Our Ref: FP/251/19/PL
Your Ref:

Development Altering of existing west access to site to allow for vehicular access for emergency & maintenance purposes only. Drop kerb formed to allow for vehicular crossover, area to include a new area of secure bin storage for the school.
fence off waiting area separating it from public access & existing vehicular entrance areas.

Location Bishop Tufnell C Of E Junior And Infant School Pennyfields Felpham

Thank you for the information you have sent following my previous letter. Unfortunately I am still unable to accept the application as valid until the following items are received or resolved:-

notes:

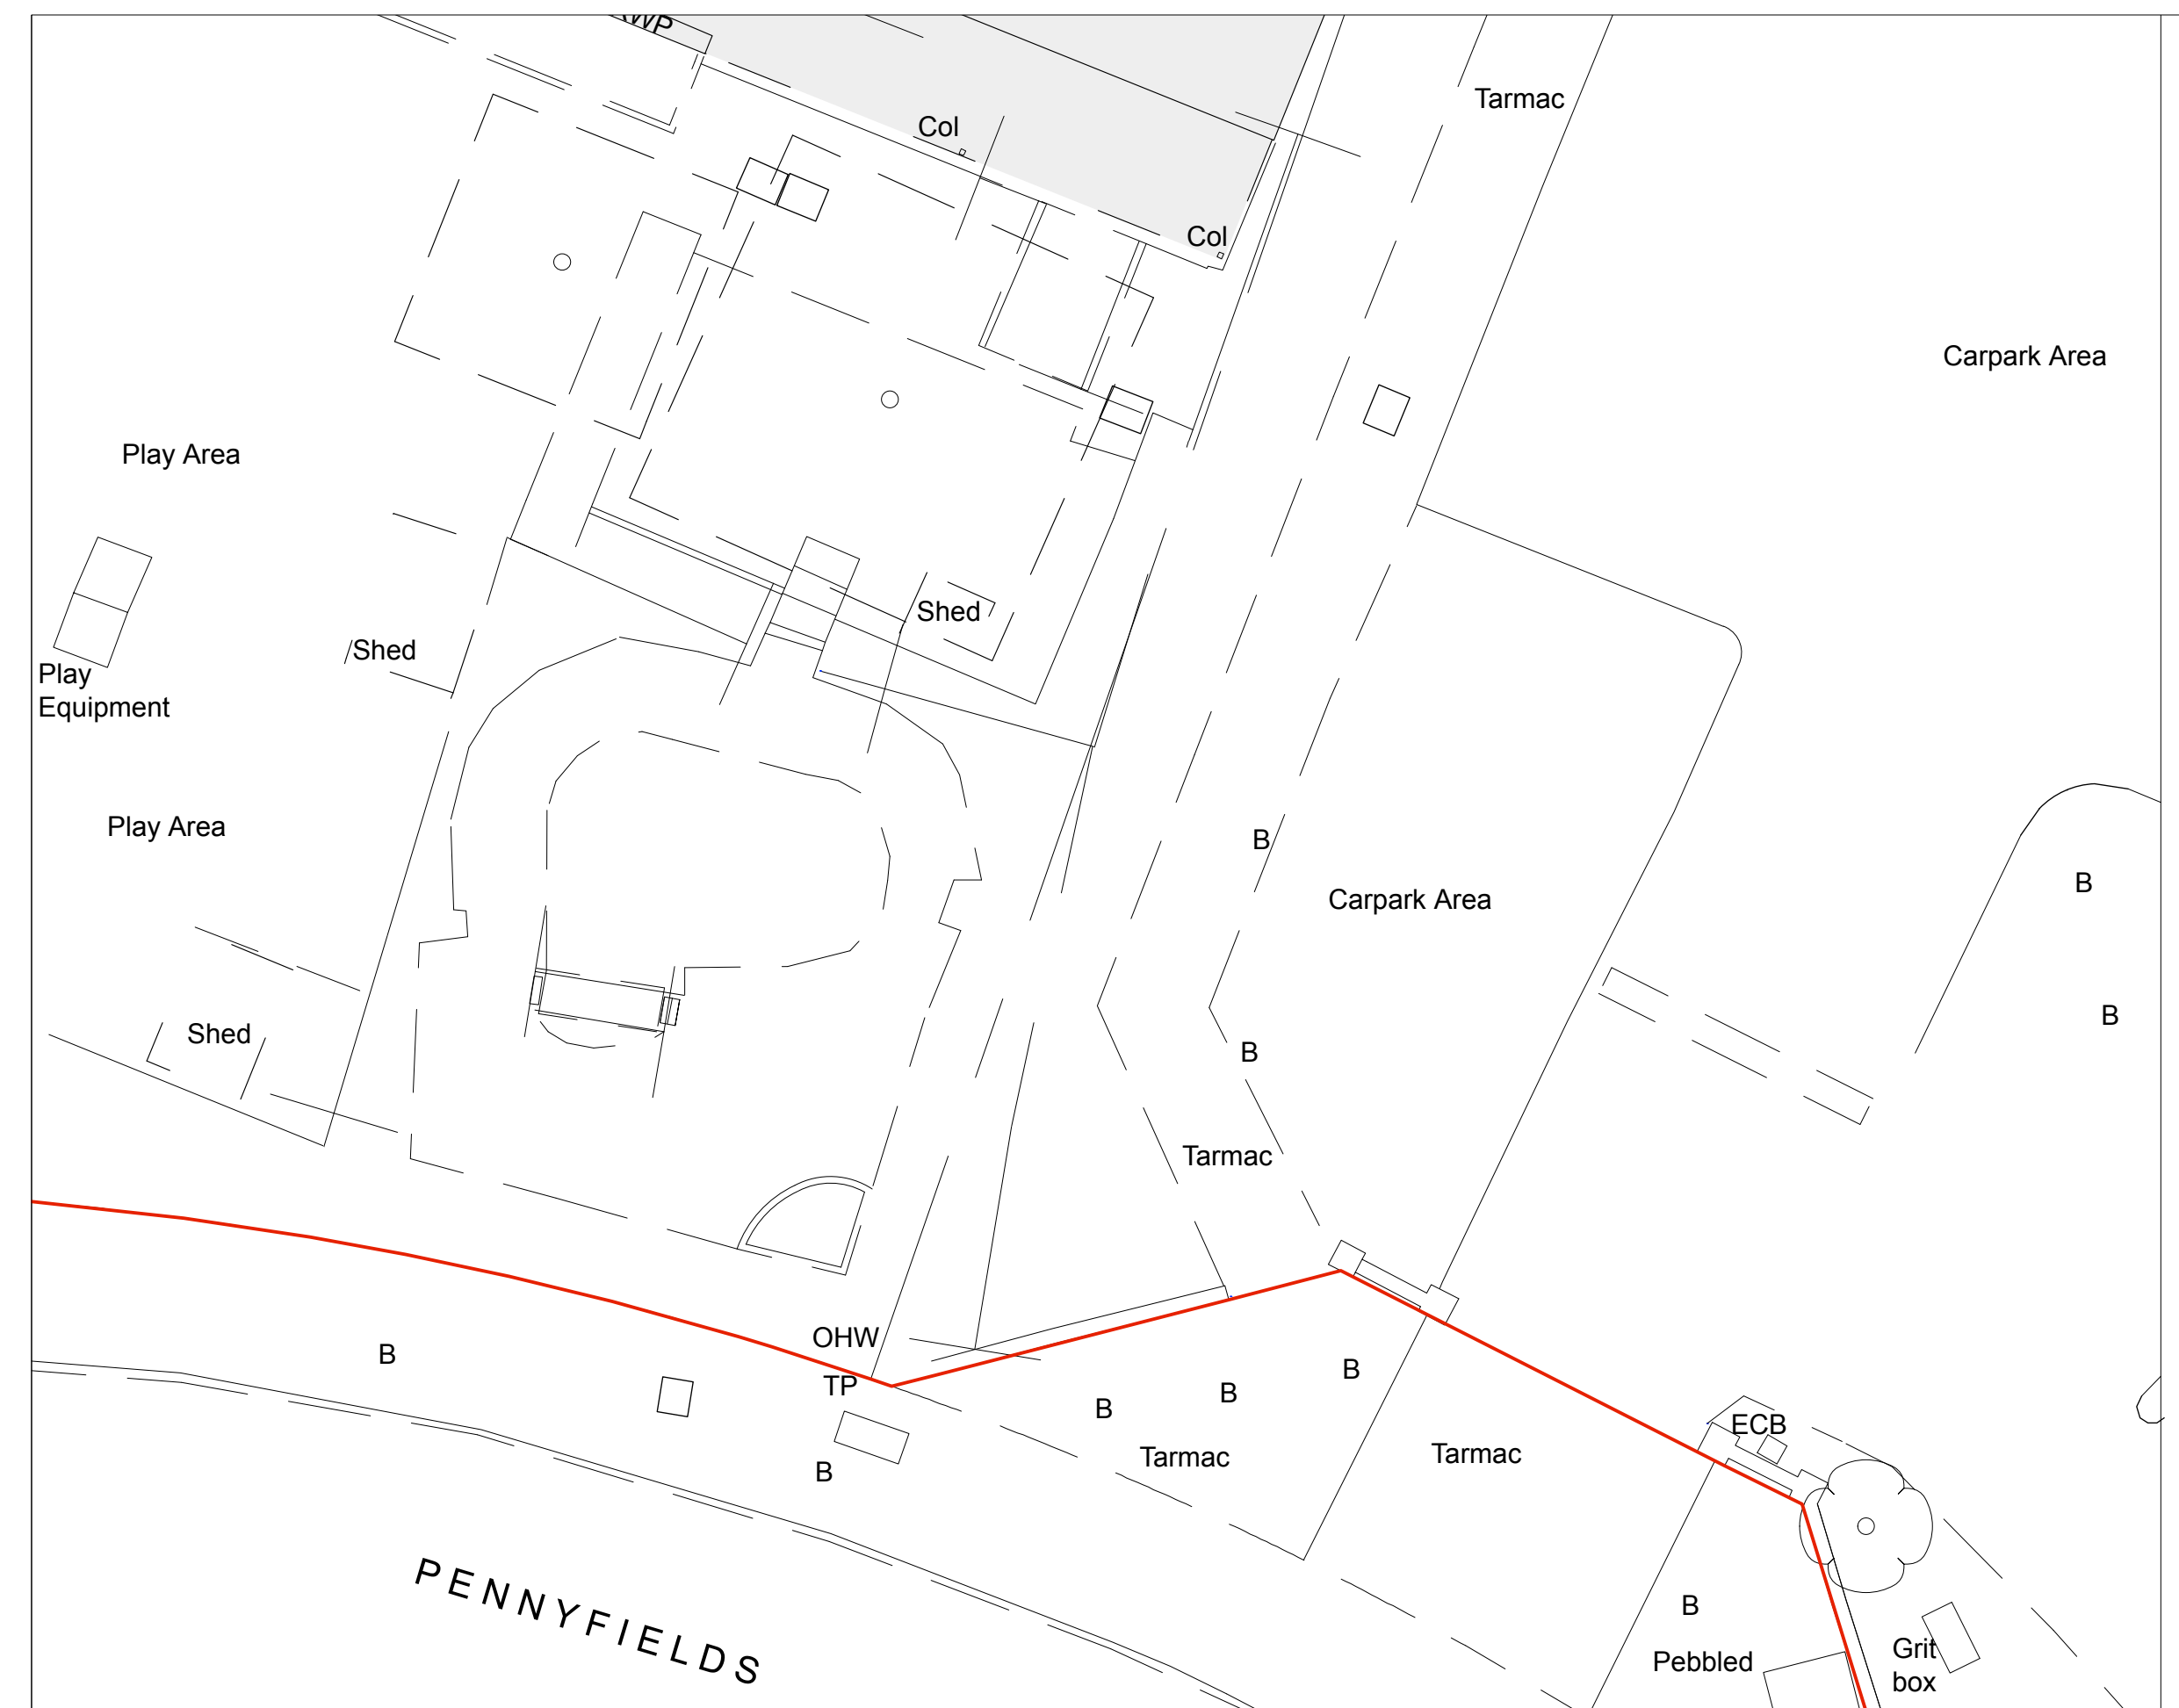
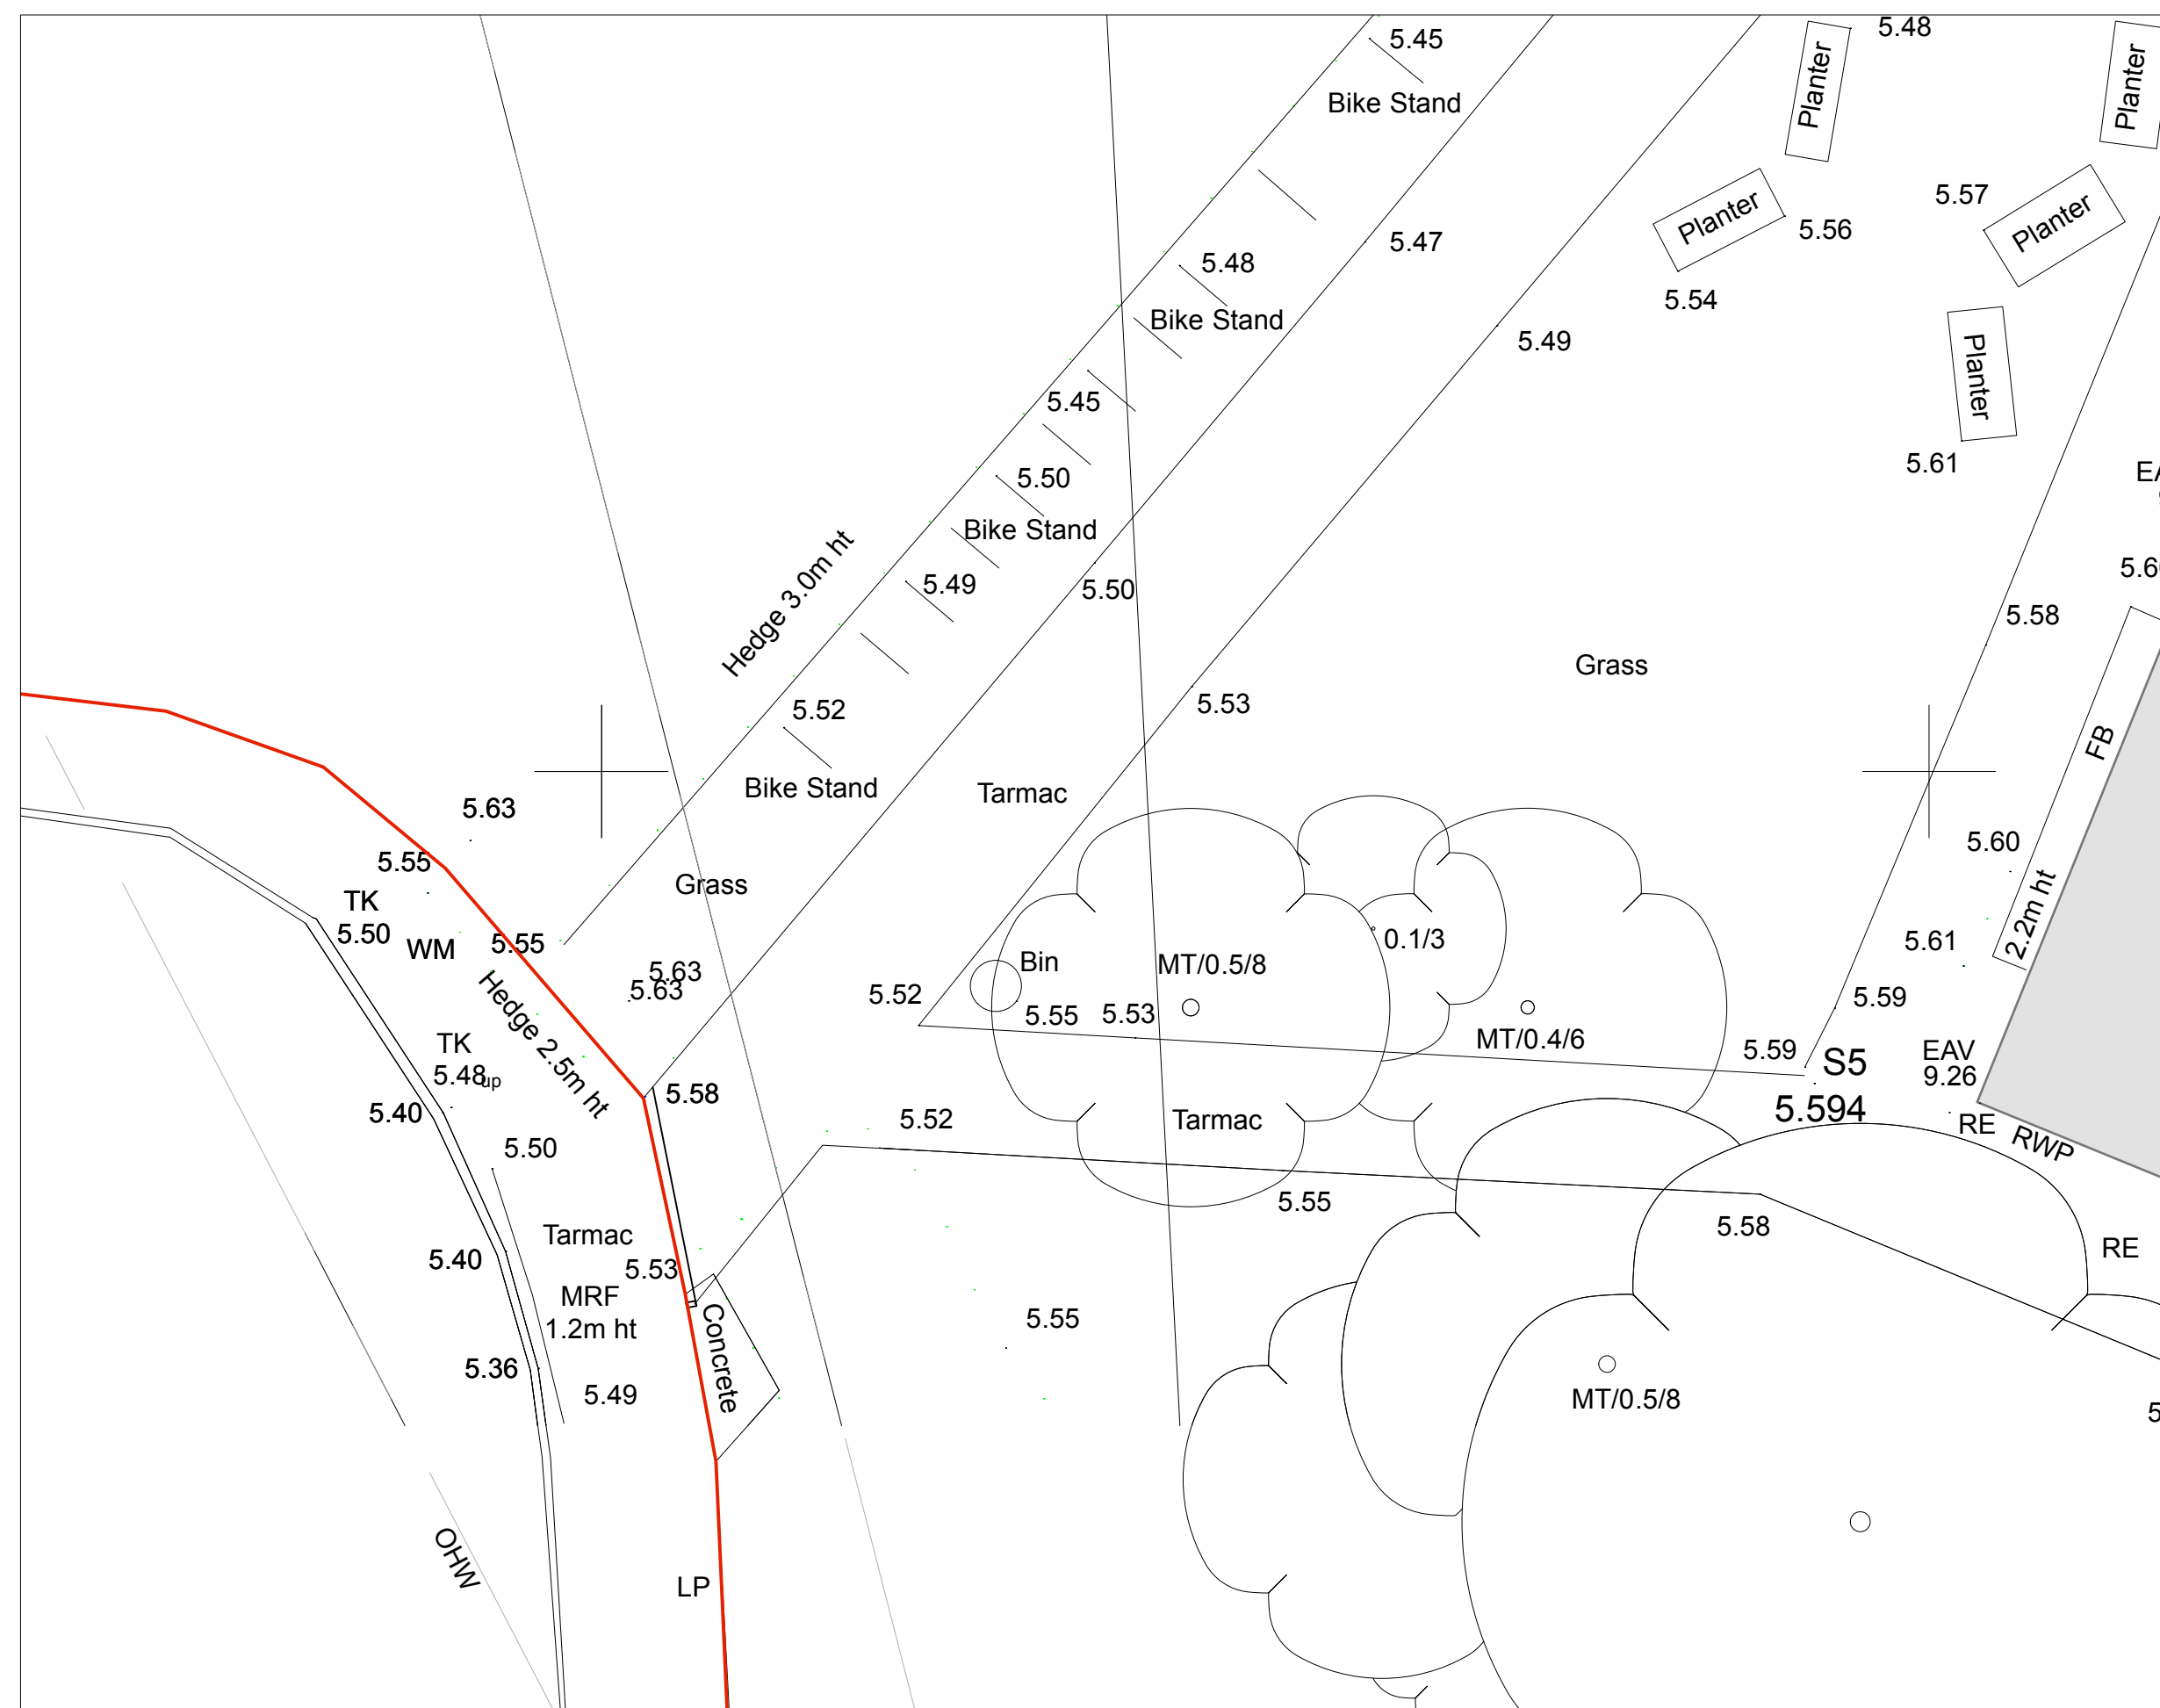
West Sussex County Council require that a visibility splay is provided. A splay is formed for a 30 mph speed limit road by measuring from a point 2.4m back from the kerb edge in the centre of the proposed access. A line should then be drawn from either side of this point for 43 m in each direction to the nearside edge of the carriage way. The splays must intersect land only within the control of the applicant, or within the publicly maintained highway.

The distance will increase with the speed limit of the road. If the road is 40 mph speed limit then the distance should be 120 m either side. For speeds above this please contact West Sussex County Council Highways for advice on what would be acceptable.
